Subject: FW: FW: M/68/20/PL- Poultry Farm 87 Yapton Road- Surface Water Drainage Comments

Subject: M/68/20/PL- Poultry Farm 87 Yapton Road- Surface Water Drainage Comments

Thank you for consulting us. We have the following comments on surface water drainage.

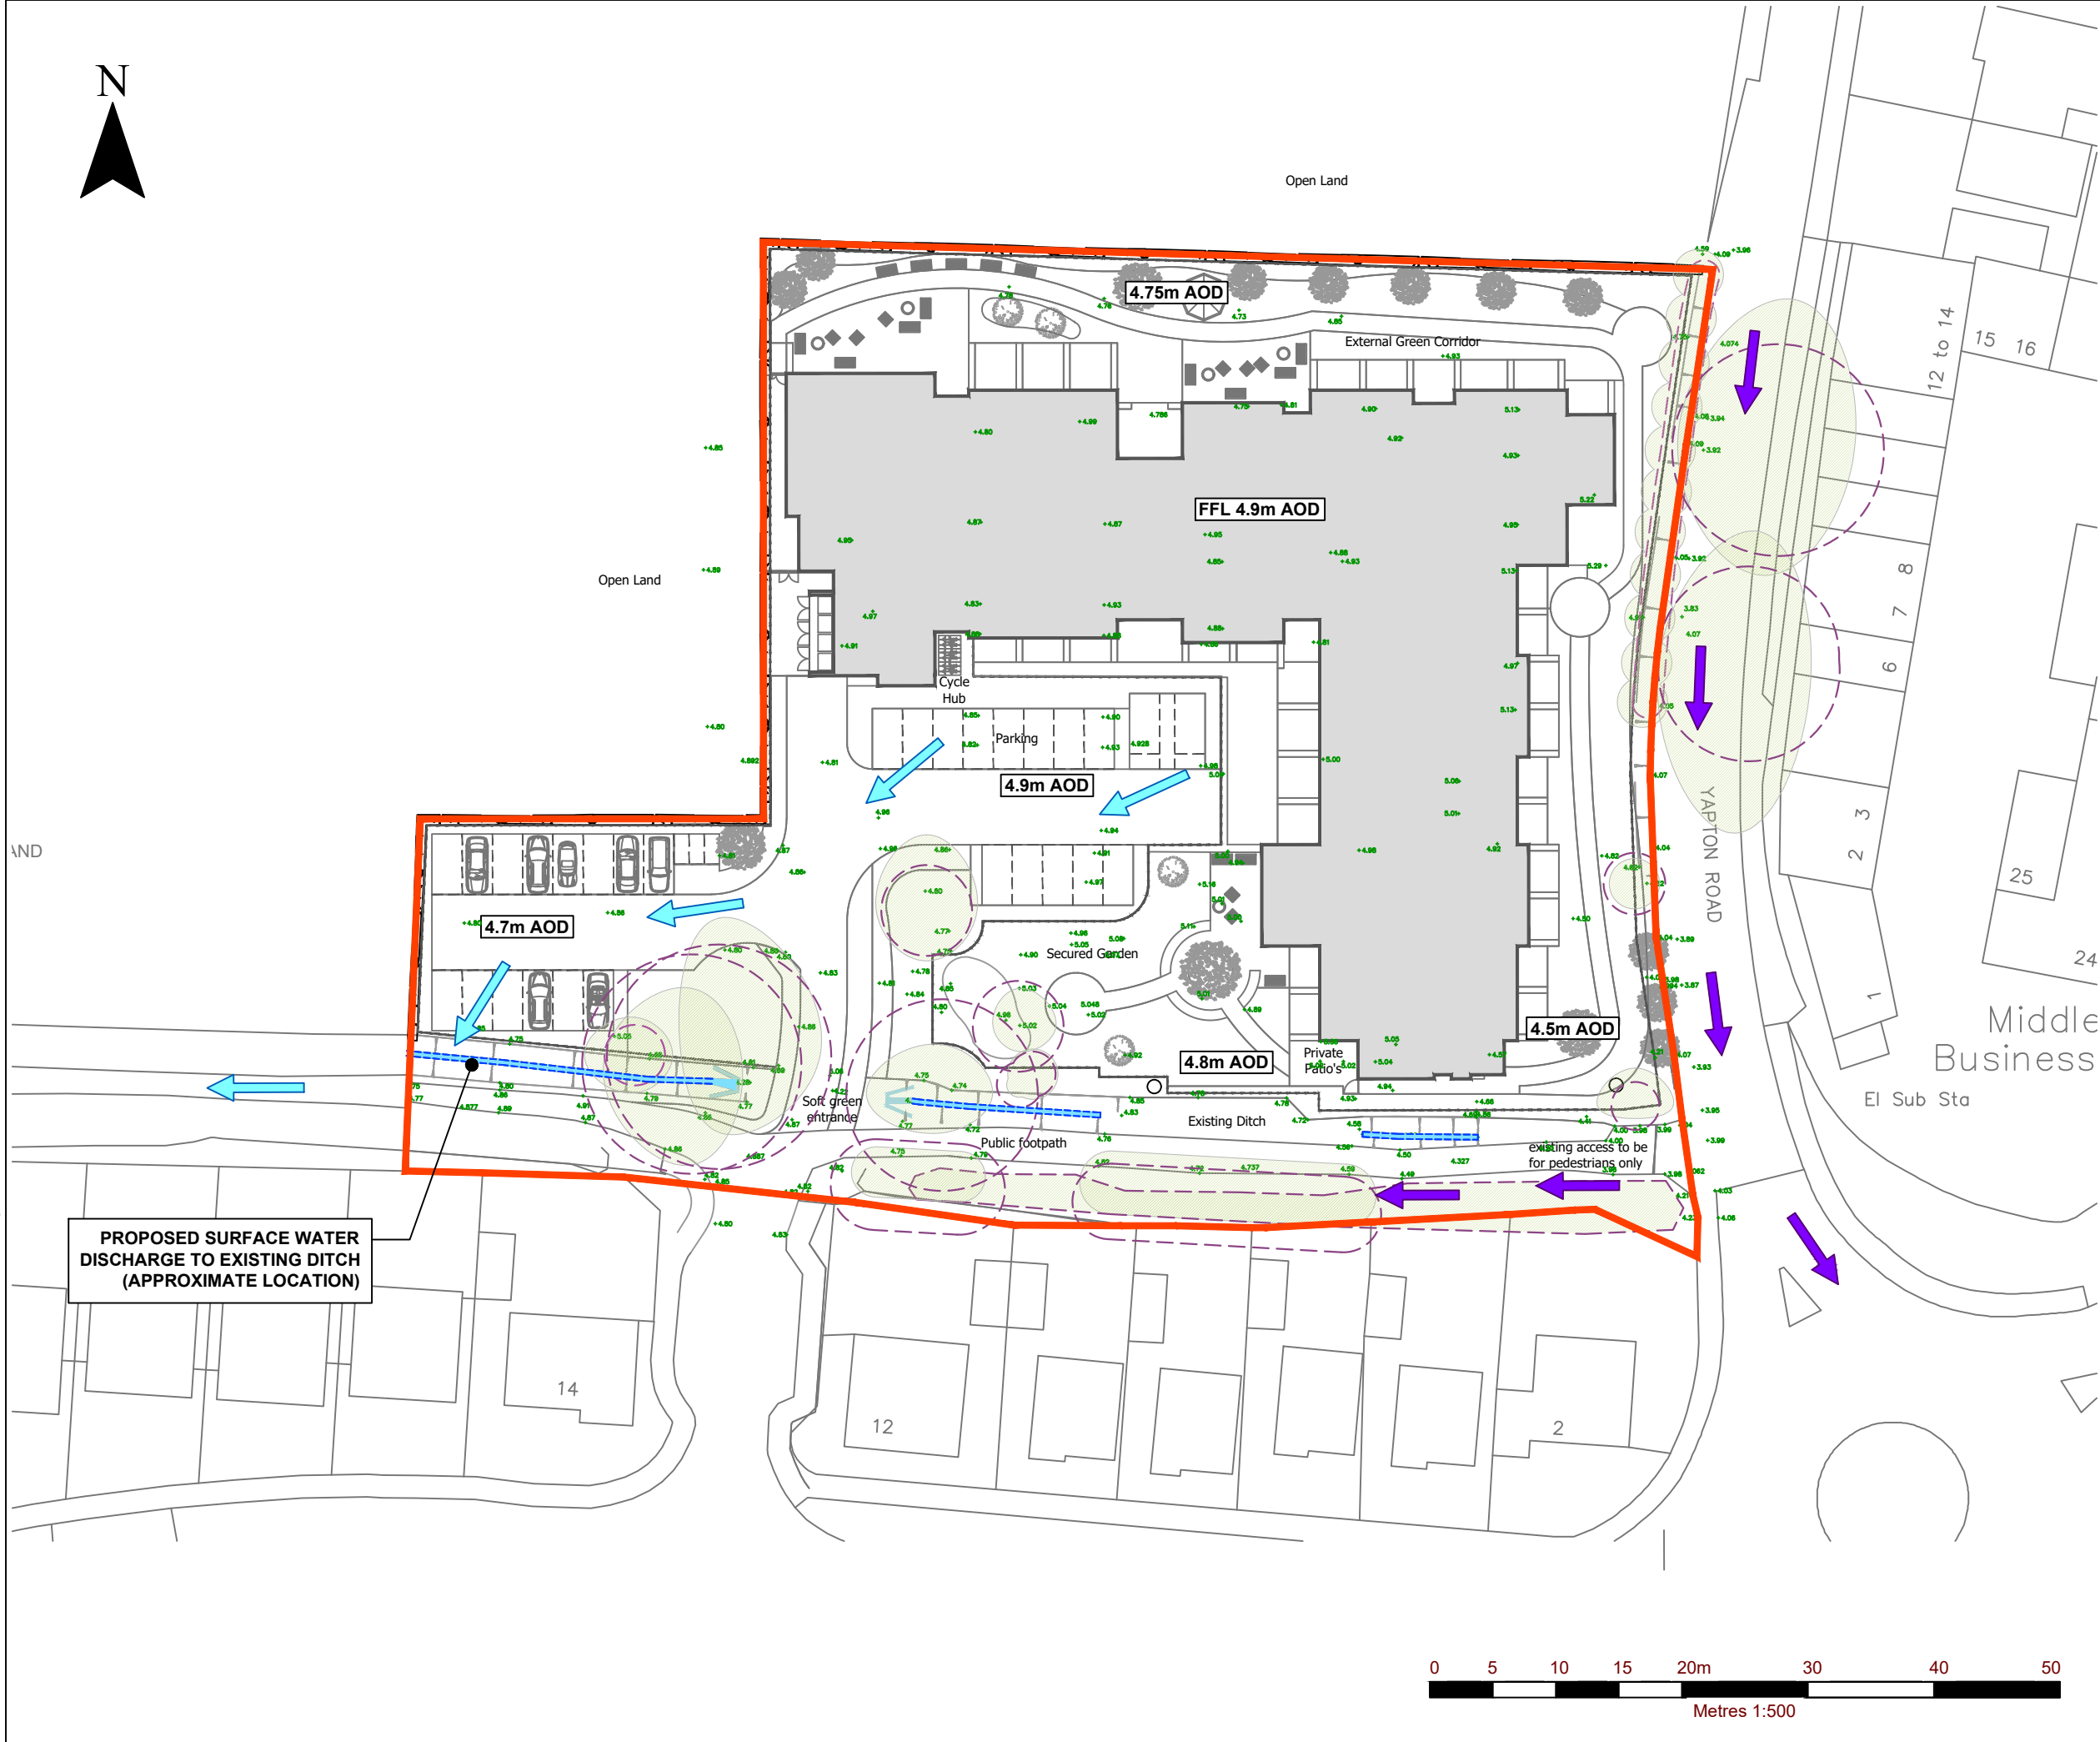
The application is a significant deviation from the previous scheme. Improvements to the drainage network are required. We will also require details of proposed site levels, with differences to existing levels clearly shown. Proposed and Existing topographical levels now clearly marked on SWDS Drawing SWDS 03.

Proposed crates must be kept at least 3m from top of bank of ordinary watercourses Amended on revised SWDS drawing SWDS 03. We have concerns regarding conflict between the draft drainage strategy and trees. Tree Protection Areas now marked, and amended crate layout provided on updated Drawing SWDS 03. On this basis we wish to place a **holding objection** on this application. It has not been demonstrated that there is adequate space within the proposed layout for surface water drainage. It is essential to establish if there is adequate space for surface water drainage prior to agreement of site layout. Drainage should be a fundamental consideration in design. Failure to secure a robustly evidenced implementable drainage strategy at this stage will likely unduly prejudice the drainage design and result in proposals failing to meet policy requirements. Please see amended layout that we consider is deliverable within the site constraints for approval at this concept stage.

A drawing that clearly shows trees that are to be retained, the root potential areas and the proposed drainage. Please see attached Drawing SW1 that clearly depicts retained trees and their root protection areas clearly marked for approval.

Based on the information provided it is clear that there is some conflict between existing trees and proposed crates. There are no crates shown within root protection areas. Therefore, we are confident that by either adjusting the drainage strategy or discussing this further with the tree officer that a solution will be achieved and can be secured through conditions.

Arun DC Drainage Engineer Request	SLR Provision
1. We will require details of proposed site levels, with differences to existing levels clearly shown;	See updated Drawing SWDS 03 attached.
2. Proposed crates must be kept at least 3m from top of bank of ordinary watercourses;	See updated Drawing SWDS 03 attached.
3. Proposed impermeable areas plan,	See updated Drawing SWDS 01 and SWDS 02 attached.
4. A drawing that clearly shows the above and the trees that are to be retained, the	See updated Drawing SWDS 03 attached.
